Date: April 19, 2021
To: Rachael Stevie, Planner
From: Craig Jones, Development Coordinator *CJ*
Through: Derek Mayo, City Engineer *DKM*
Re: Bull Rd & Umptanum Rd – Bull Ranch – SEPA LP-21-00001

The following are the City Public Works SEPA comments for the proposed The Bull Ranch on the east side of Bull Rd at Umptanum Rd.

W
A
T
E
R

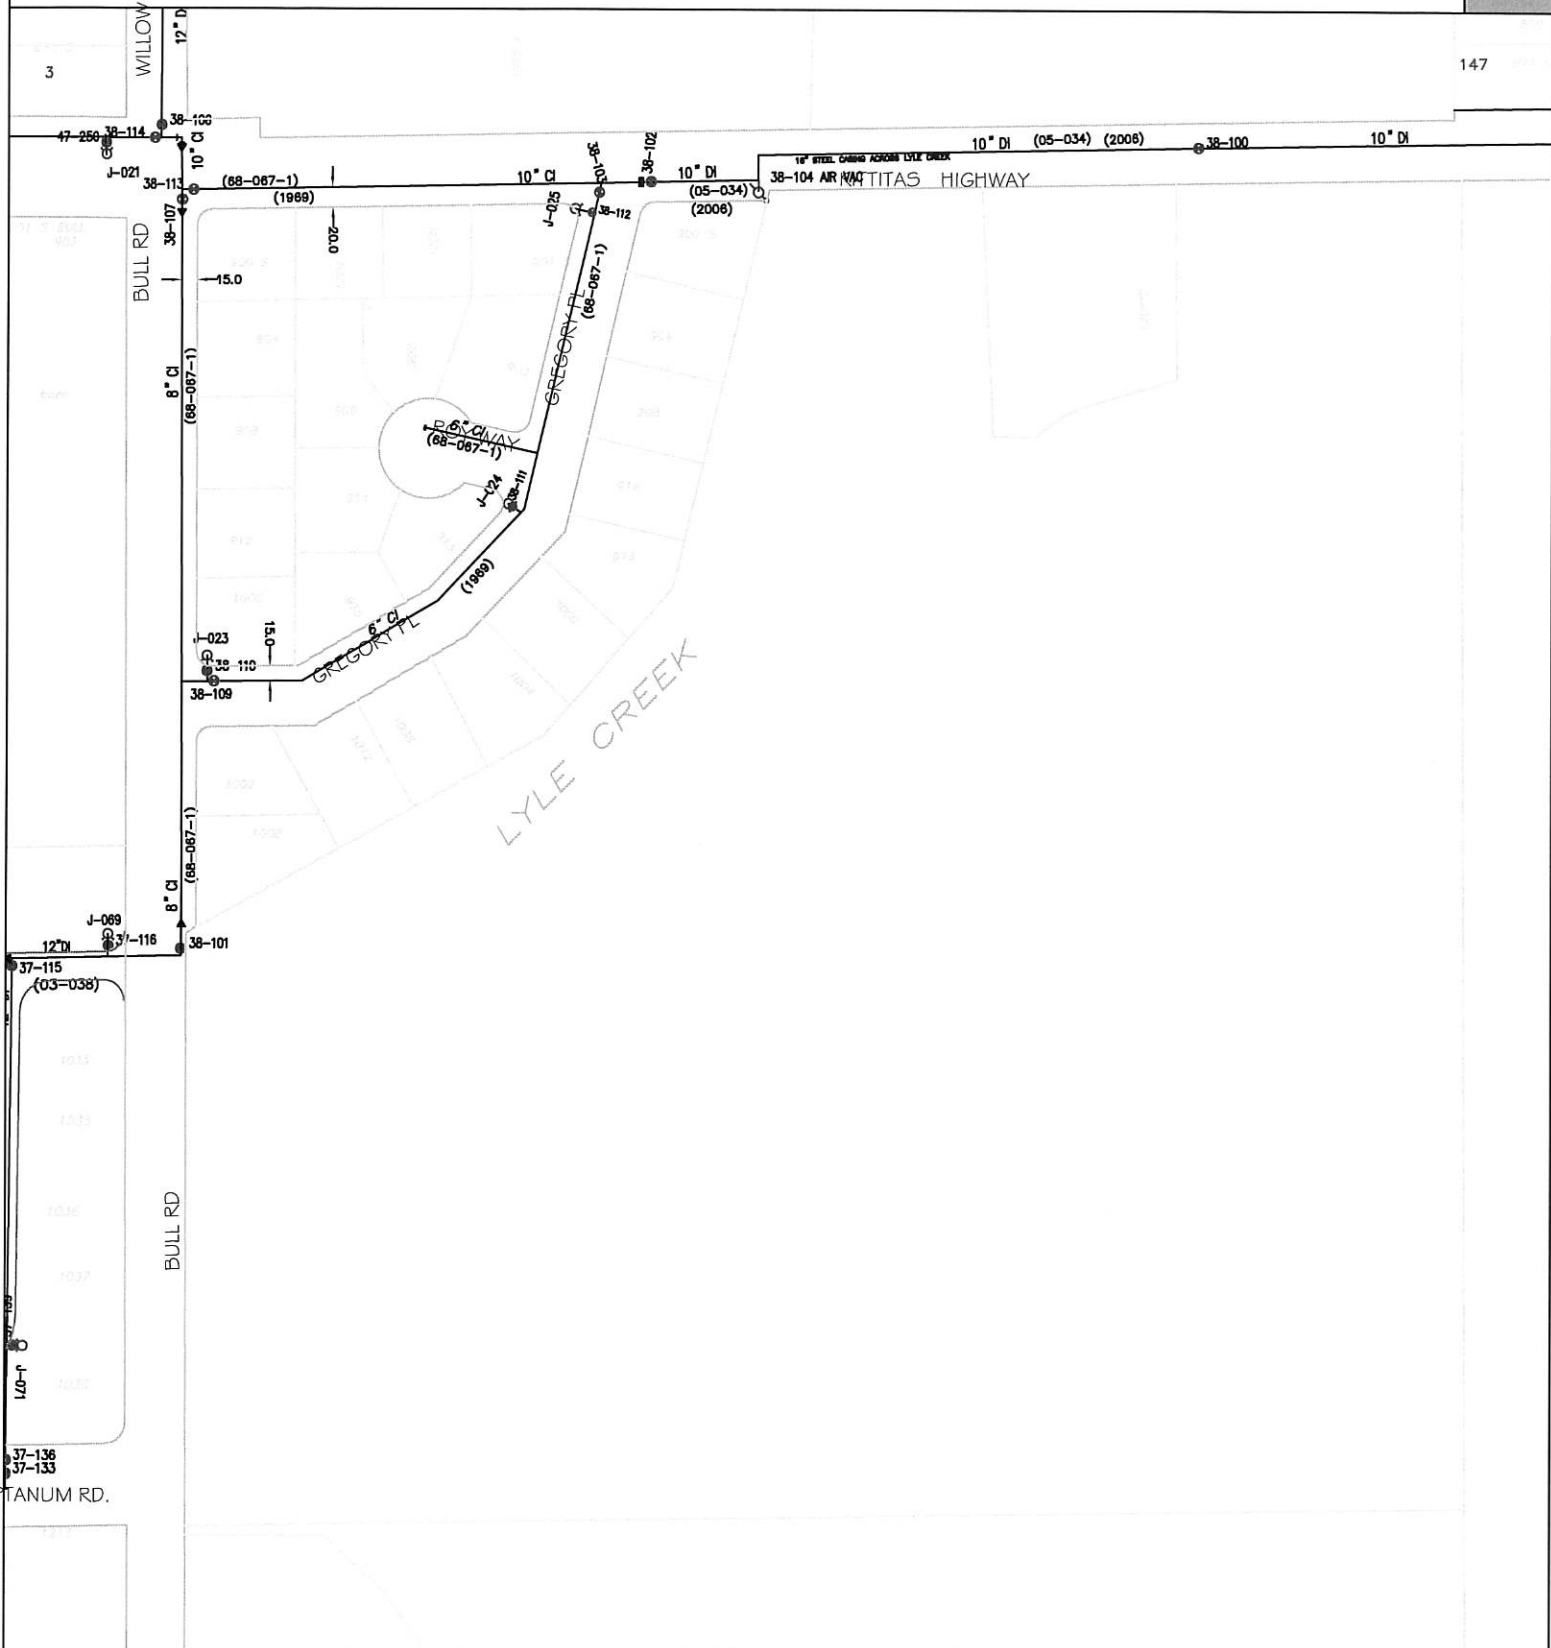
The water mains available to serve this development are a 10" Ductile Iron main that runs in Kittitas Highway and an 8" stub is being installed at Umptanum Rd extension as part of the City's Bull Rd project. The developer will need to build an 8" water main on all the proposed interior roads. Each lot will need a separate water service. The maximum number of lots that can be served by one water connection is 40 lots. The water system will need to be looped between Kittitas Hwy and Umptanum Rd. See attached utility map.

SEWER

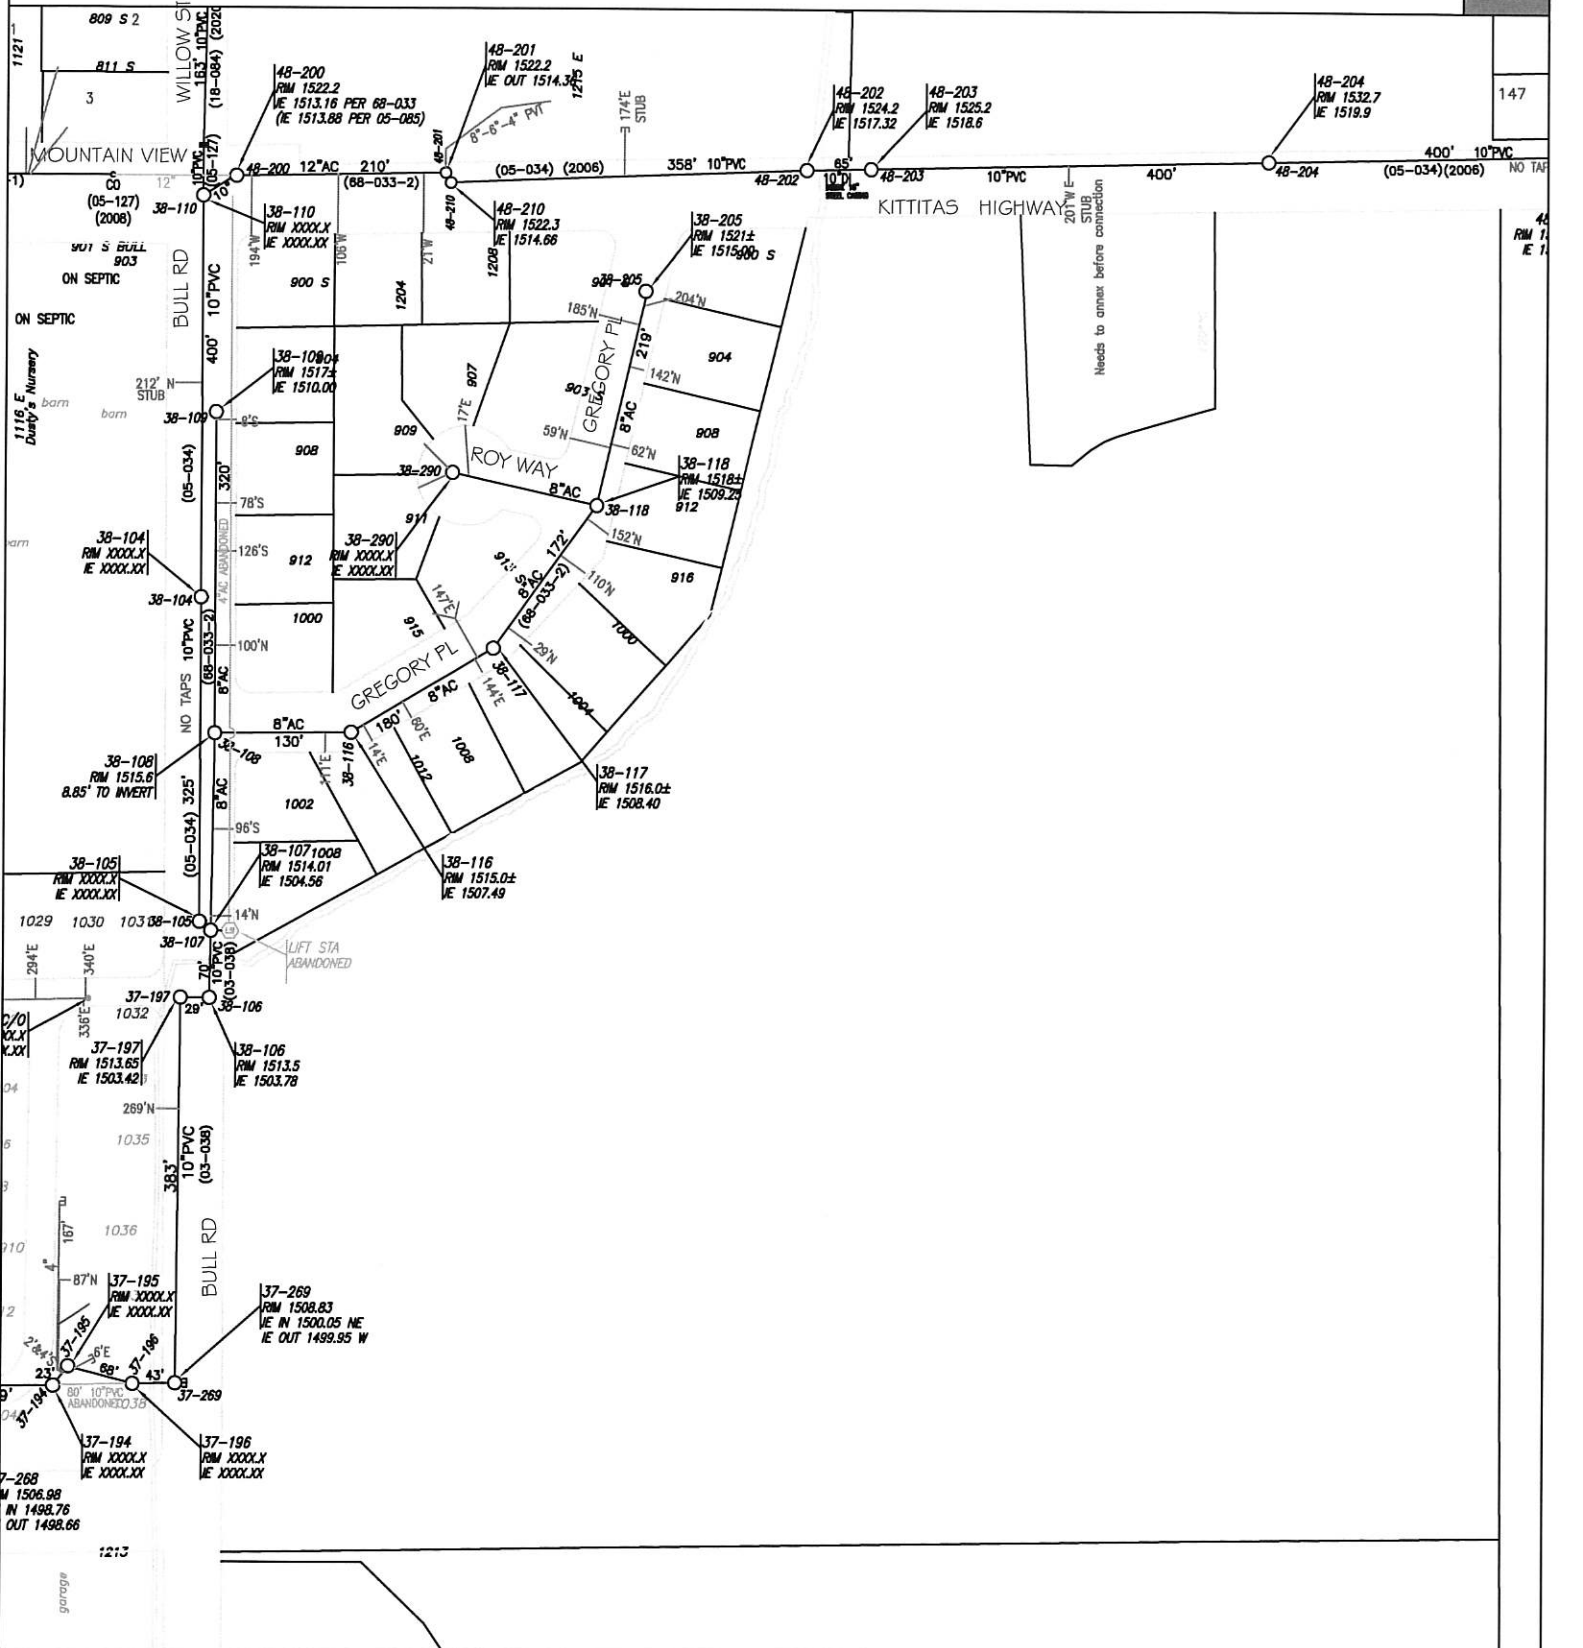
The sewer mains available to serve this development are a 10" PVC main in Kittitas Hwy and an 8" stub is being installed at Umptanum Rd extension as part of the City's Bull Rd project. The developer will need to install 8" sewer mains on the interior roads and side sewer stubs to each lot. See attached utility map.
